Planning Department  
Brennon Williams, Director

December 9, 2020

**Re: West Mesa RV Park – 10125 Volcano Rd. NW  
Erosion Sediment Control Plan  
Engineer's Stamp Date 11/30/2020 (B08E003)**

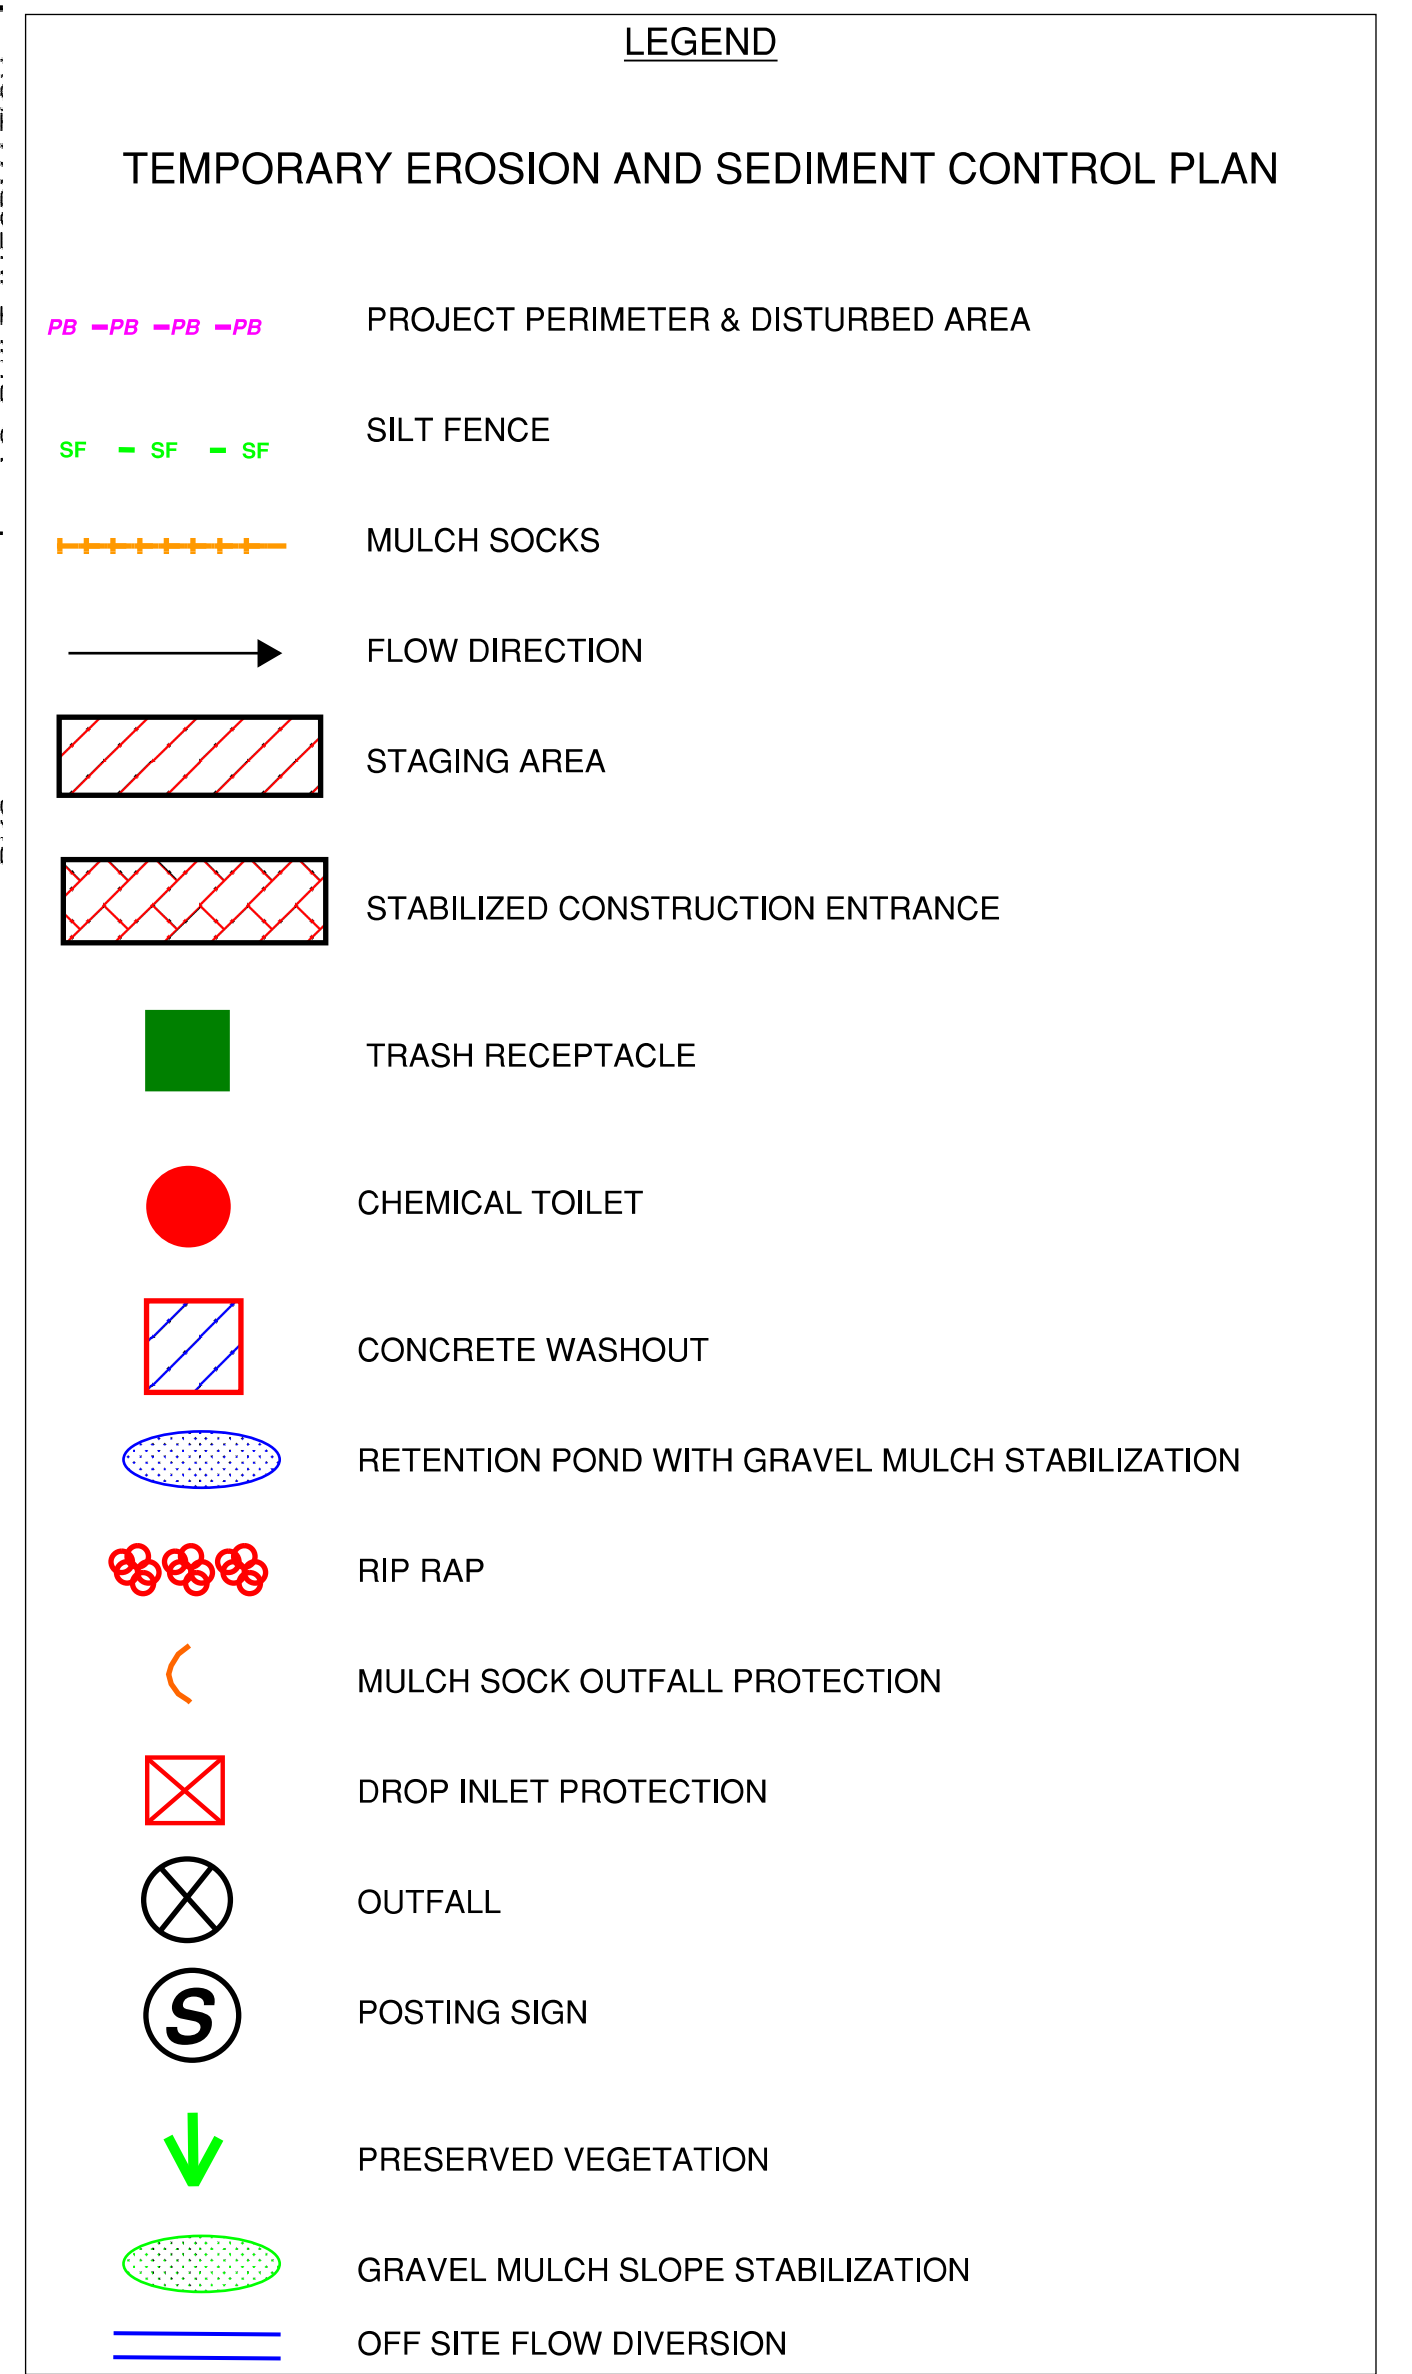
1. Permanent stabilization – site specific stabilization is missing in several areas, the pond, and the swale and slopes north of the pond, and the inlets and outlets to the culverts. The hatching on the pond is not identified in the legend. Standard seed and mulch does not meet the Final Stabilization Criteria (CGP 2.2.14.b) unless the mulch is maintenance free for 3 years or unless perineal vegetation provides uniform coverage at 70% of natural density. Describe the design and construction specifications of the stabilization.

2. Provide a strategy to manage stormwater from the large upstream offsite basin that drains through this site during construction. The sequence should be

3. The size of this site exceeds the design specifications for silt fence, so a sediment trap is needed at the low corner of the site. Provide discussion of the design specifications, construction specifications, maintenance schedules (short and long term), inspection criteria, and expected performance and longevity of the BMPs.
